Town & Country Planning Act 1990 (as amended)
Town and Country Planning (Development Management Procedure) (England) Order 2015
Approval of details reserved by condition imposed under FG/39/18/PL relating to conditions 3-
surface water drainage, 4-ground contamination risk, 9-position & intensity of lighting filments, 14-
lighting scheme, 15-Construction Management Plan & 16-ground contamination risk.
Garage Premises Littlehampton Road,Ferring,

Condition Number 16

Arun District Council have decided to **REFUSE details reserved by condition for the following reasons:**

FIGURE 2: INVESTIGATION LOCATION PLAN

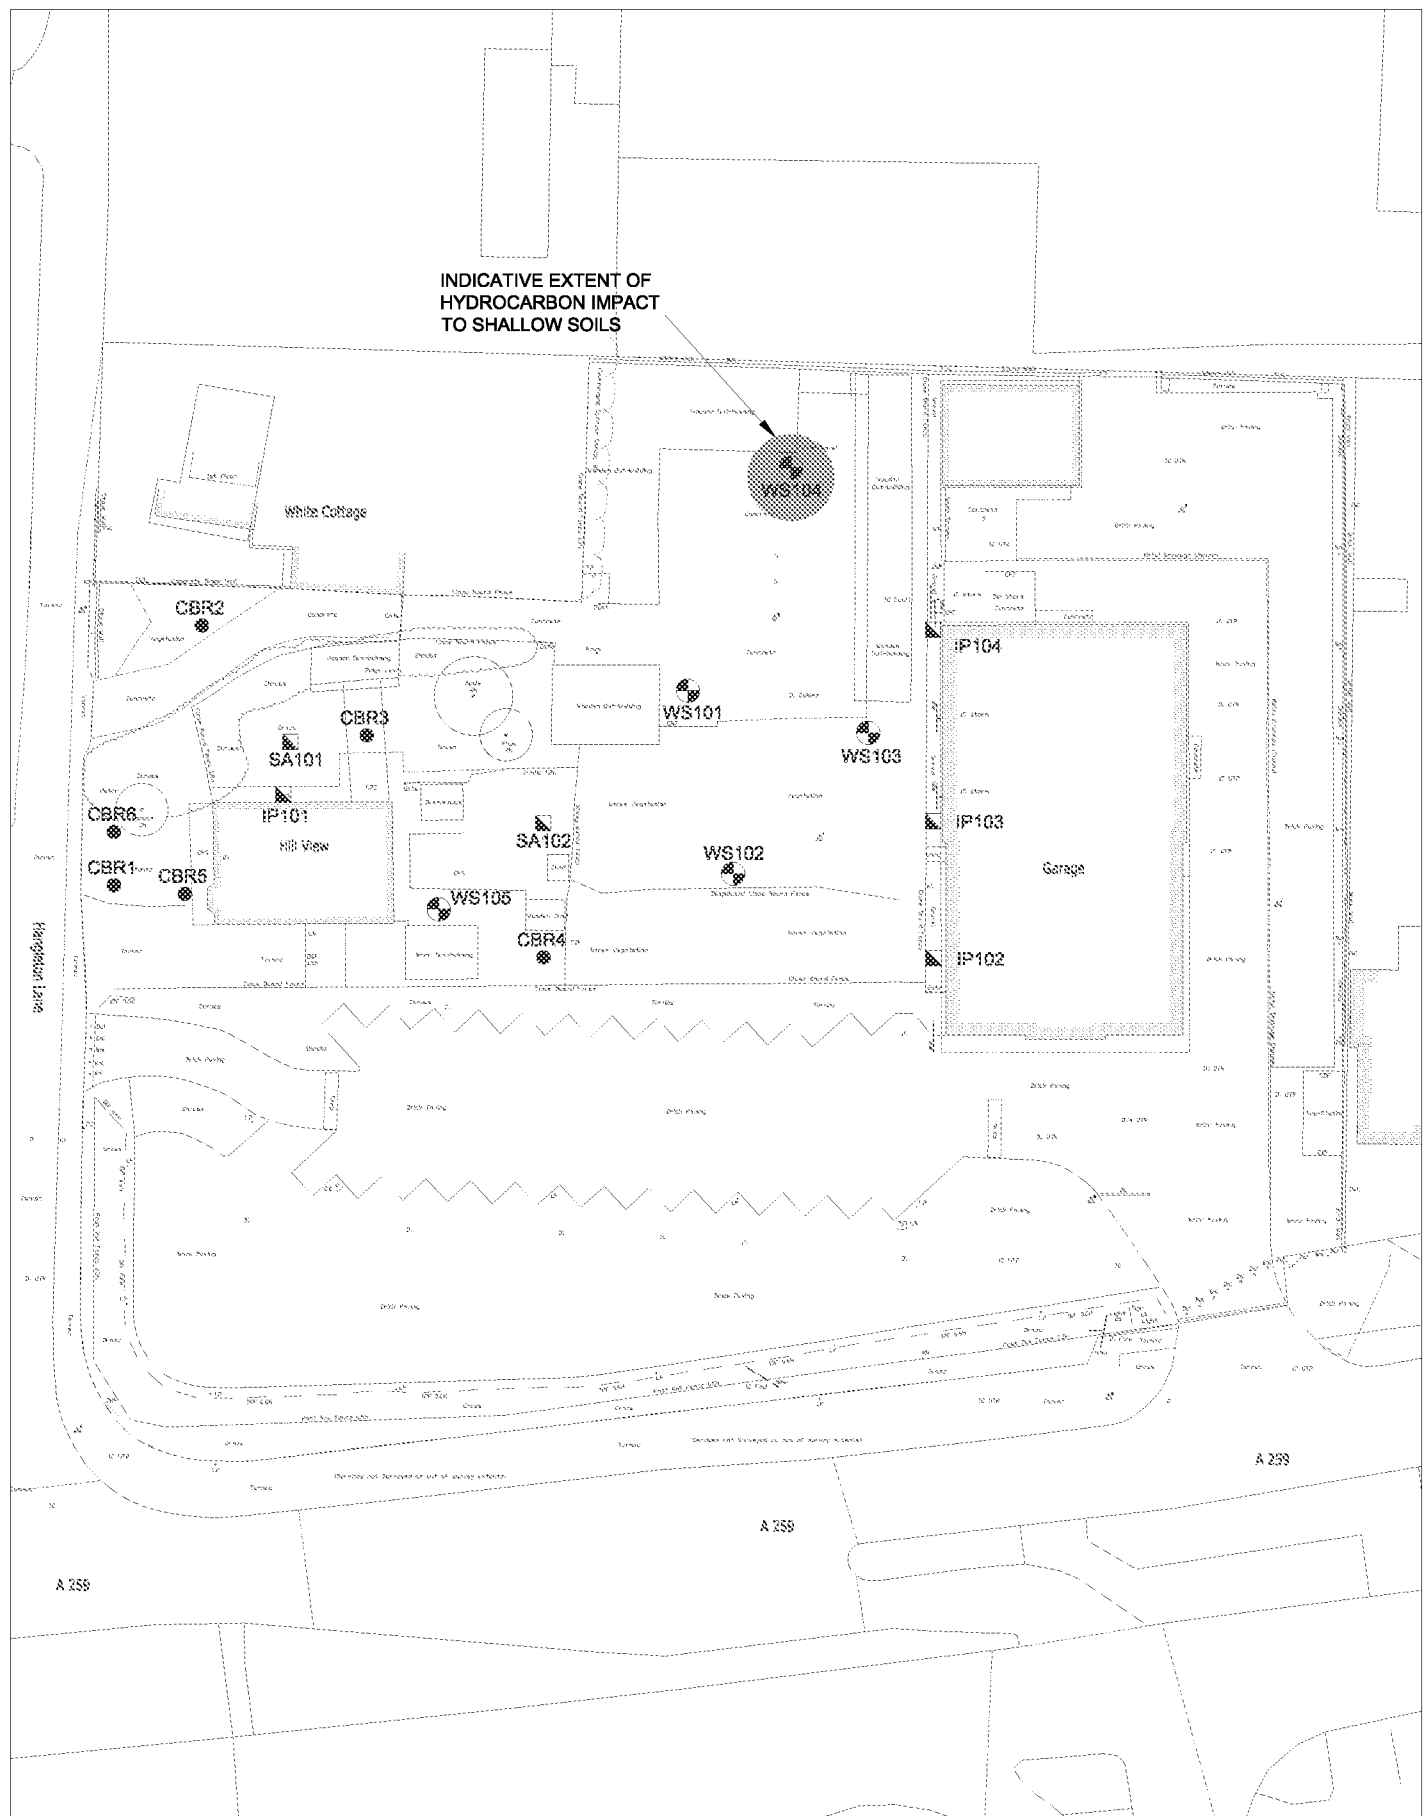
This condition is refused on the basis that the Ground Condition assessment (J18-035-R02). identifies localised hydrocarbon contamination in the vicinity of WS104 and hydrocarbon odour in WS103. Section 5.2.3 states that groundwater locally has been slightly impacted with hydrocarbon contamination already and that as concentrations in the soil are low this does not represent an ongoing source. However no samples have been taken between WS104 and WS103 and groundwater samples have not been reported.

Therefore further investigation to determine the extent of the impact in soils and groundwater around WS104 and the hydrocarbon odours observed in WS103 is required. This should be incorporated into the conceptual model and then a remediation strategy and subsequently a verification strategy submitted (if required).
